Our ref: HA/2021/123109/01-L01
Your ref: LU/84/21/PL
Date: 28 April 2021

CHANGE OF USE OF PREMISES TO A MIXED USE COMPRISING OF 1 NO. 4-BEDROOM HMO UNIT & RETENTION OF 1 NO. BED-SIT UNIT AT FIRST FLOOR; 2 NO. HOLIDAY LET USE UNITS AT GROUND FLOOR WITH REDUCTION IN SIZE OF RETAINED HAIRDRESSERS & ANCILLARY RETAIL STORAGE SPACE & STAFF FACILITIES TO BE PROVIDED AT BASEMENT LEVEL

36 - 38 SURREY STREET LITTLEHAMPTON BN17 5BH

First Floor Plan

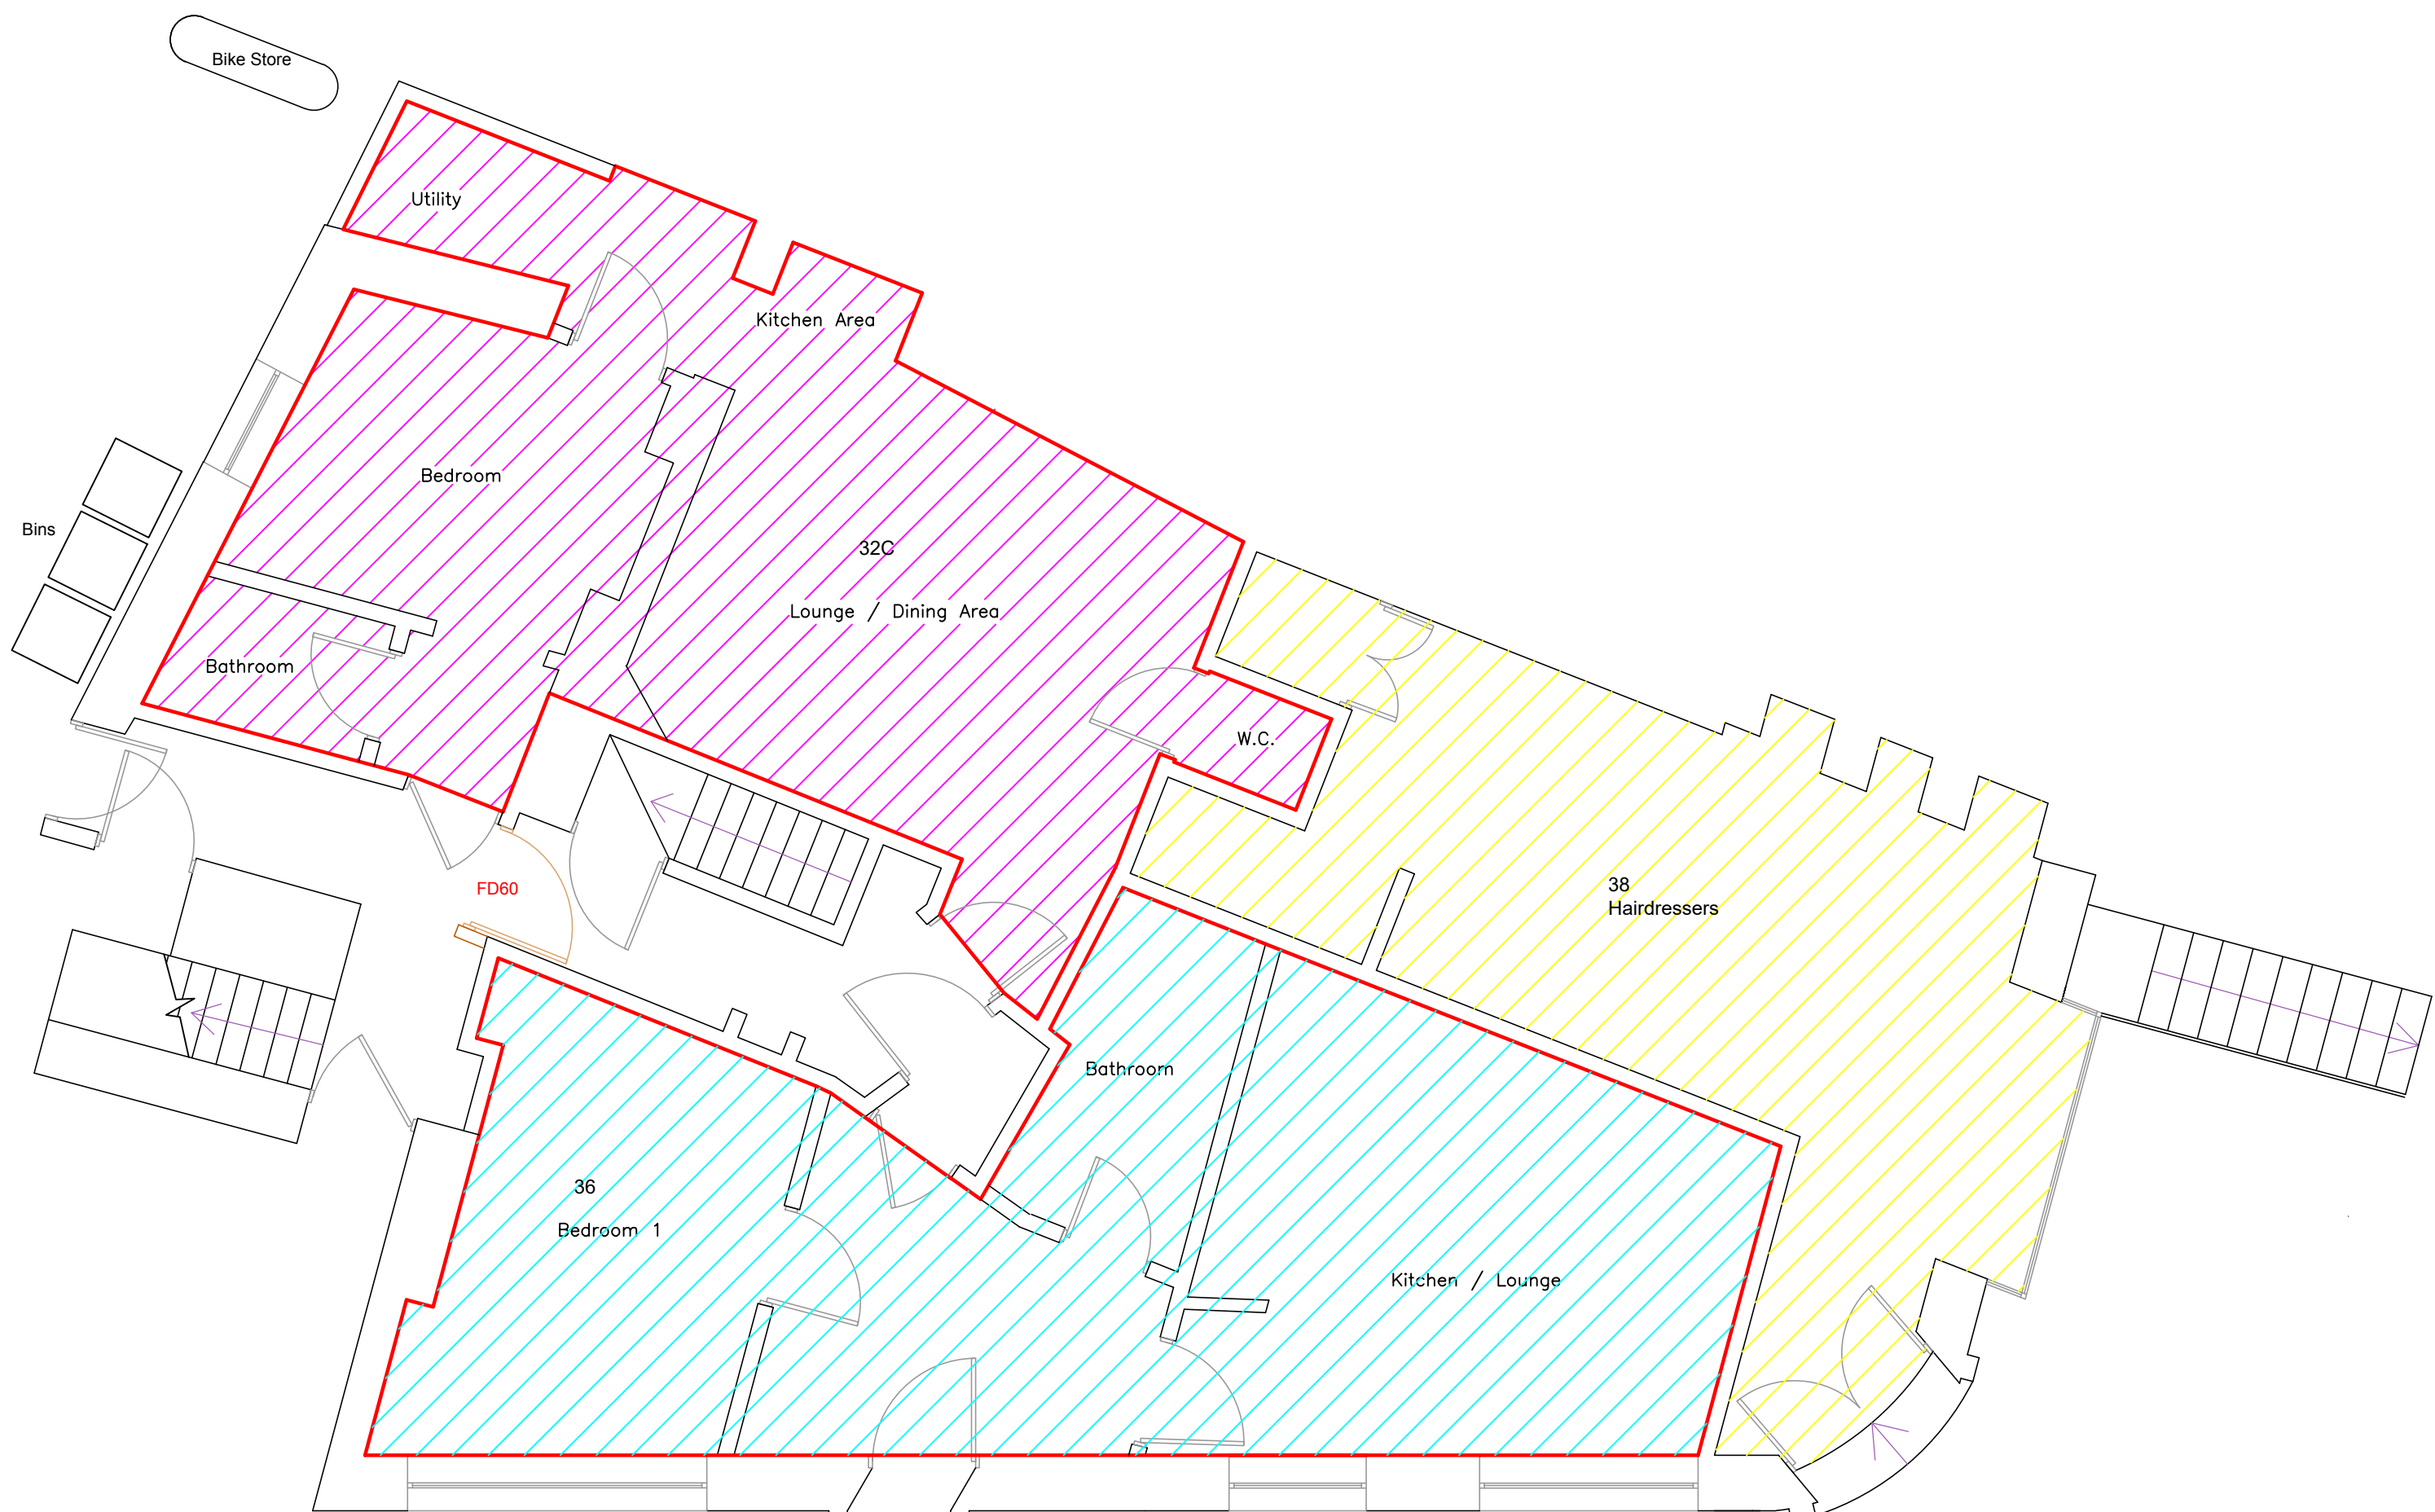
1. Nor residential or holiday let units may be placed in the basement.
2. Internal access from the ground floor holiday lets to the first floor must be maintained for use in an emergency
